# CITY OF ALBUQUERQUE

**RE: Camino Encantado – Sunset Memorial Park Cemetery  
924 Menaul Blvd. NE  
Grading and Drainage Plan  
Engineer's Stamp Date: 06/20/2024  
Hydrology File: H15D016  
Case # HYDR-2025-00225**

C100

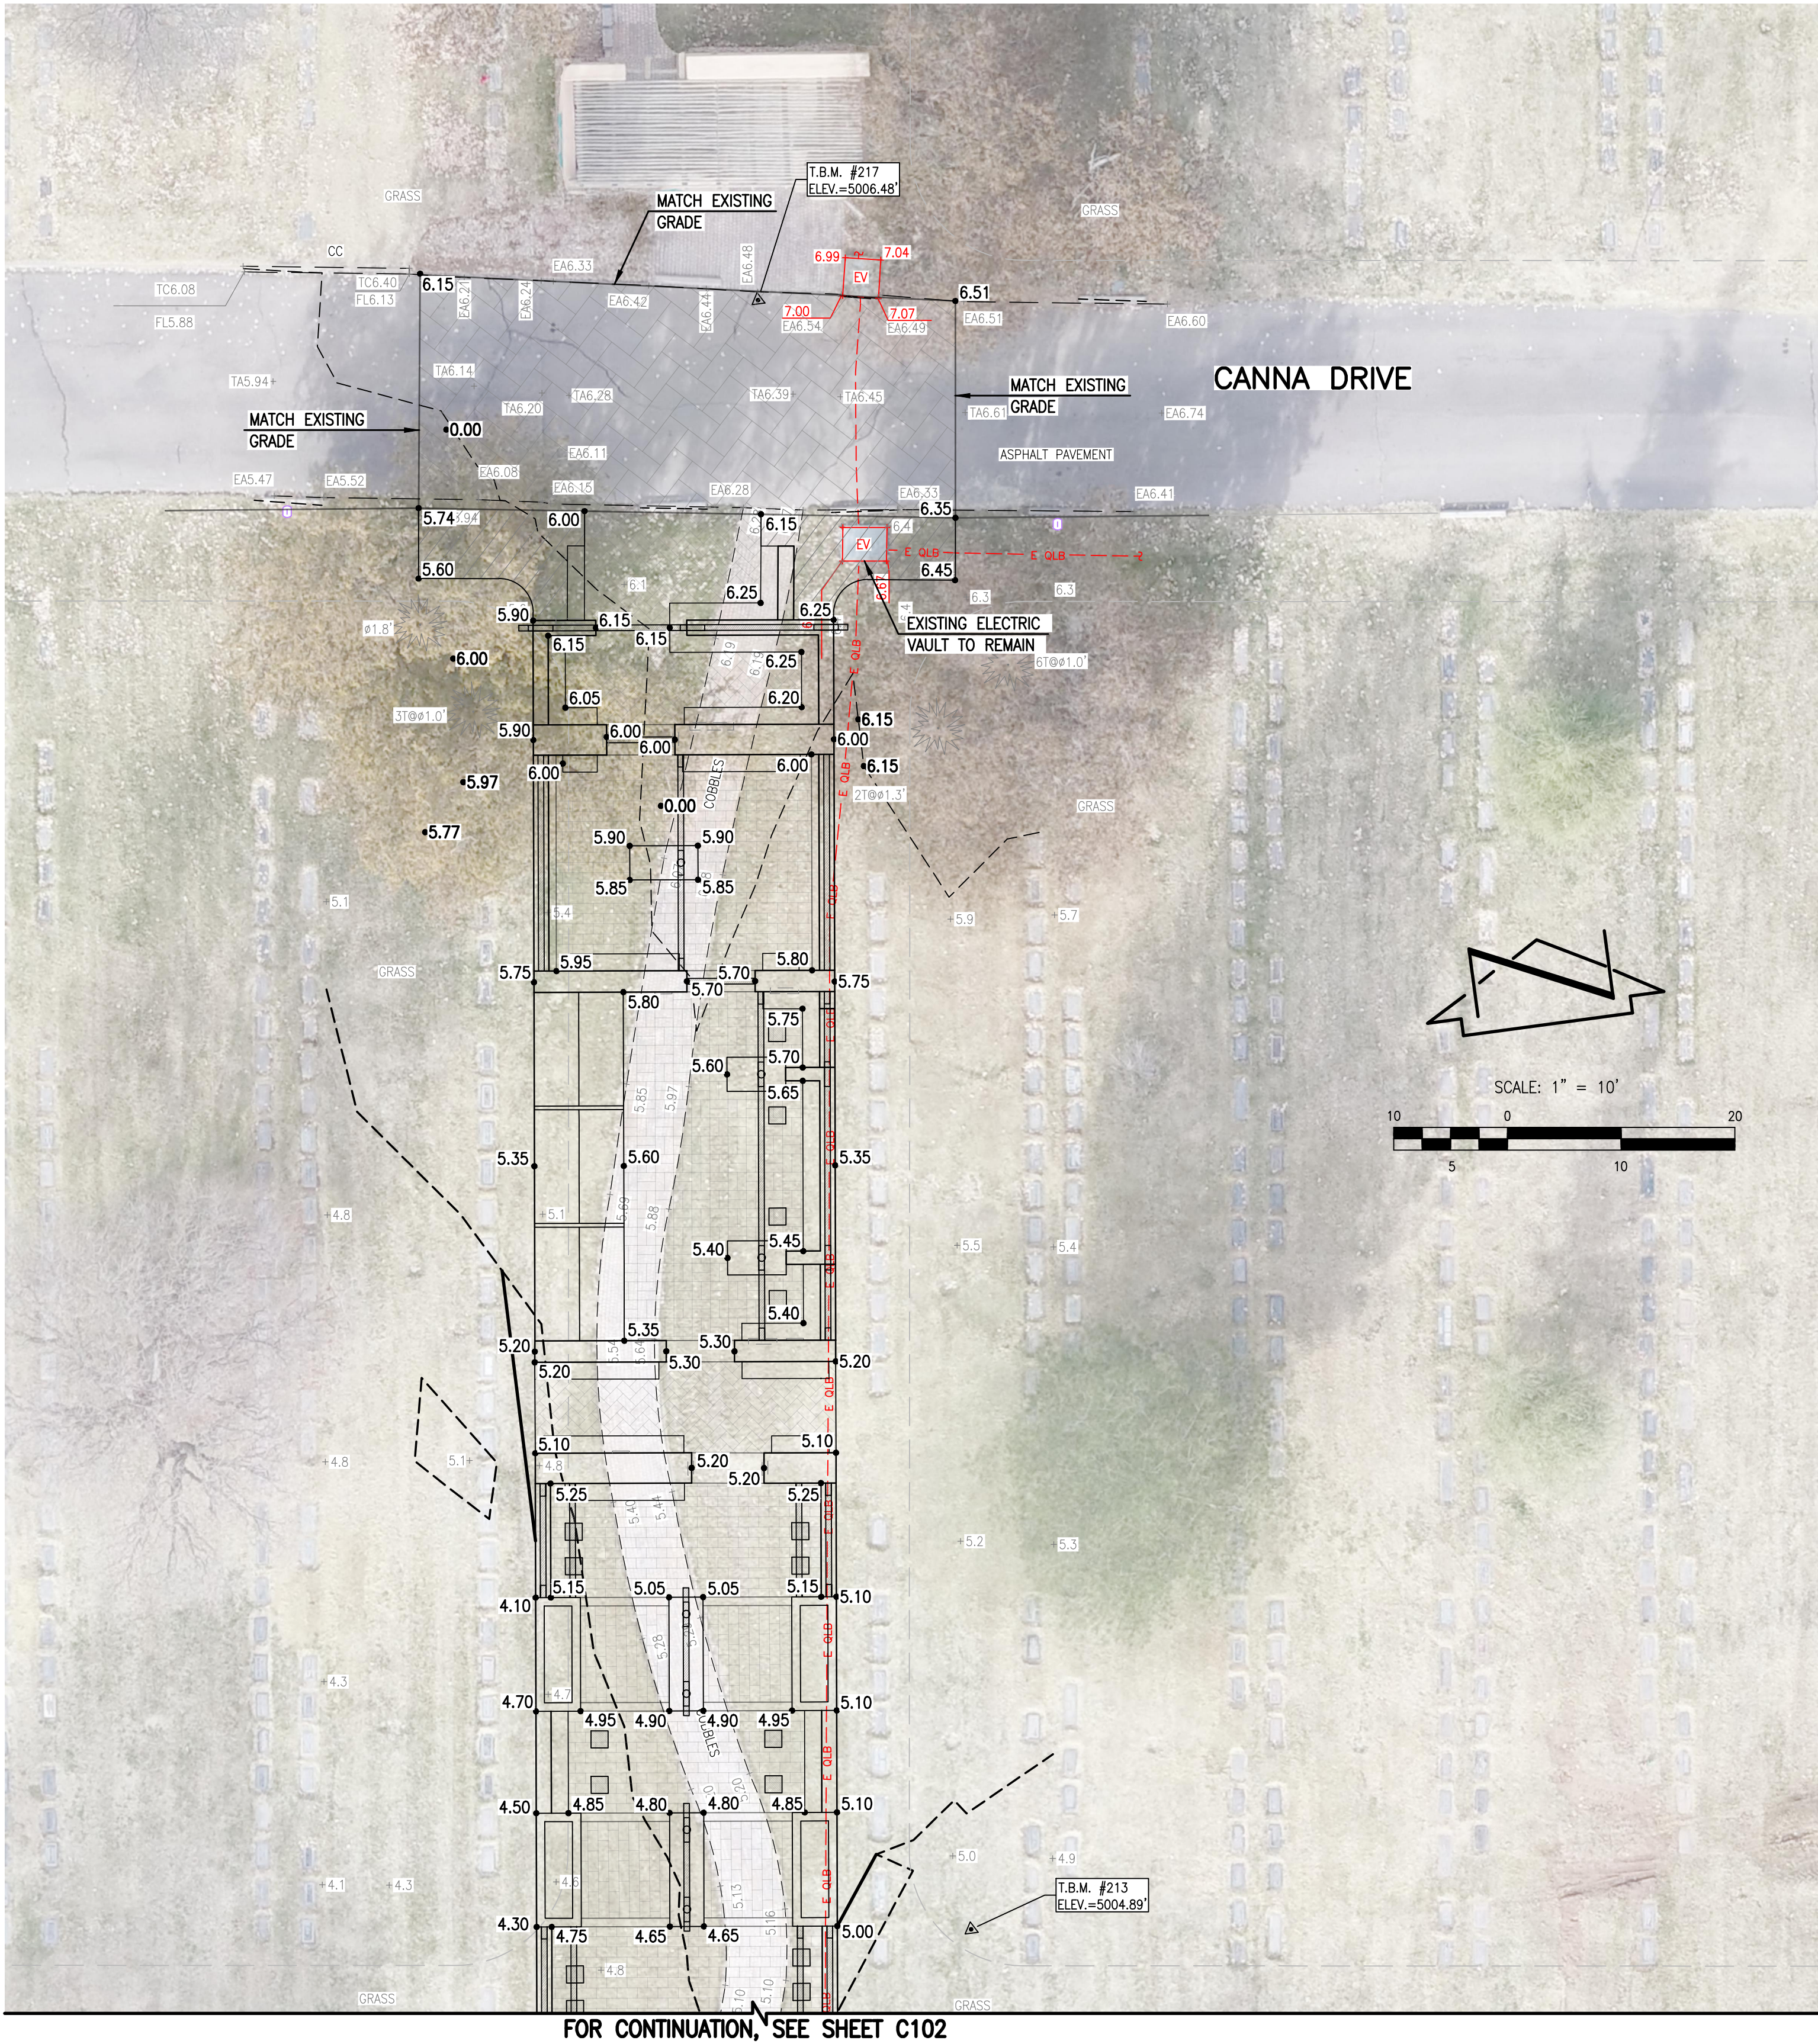
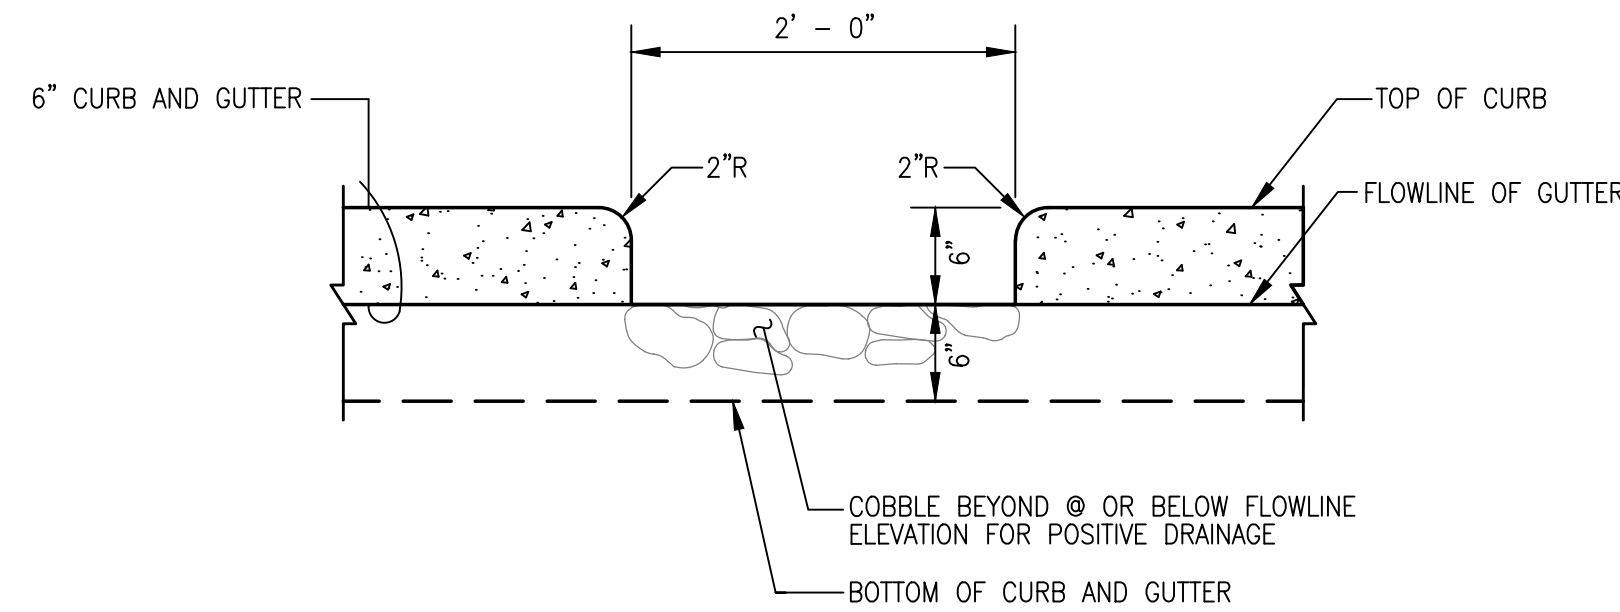
1. Please provide the FIRM Map and floodplain note with effective date.
2. Show the SWQV Calculations.
3. Add a note if a waiver for SWQV is to be waived for this site.
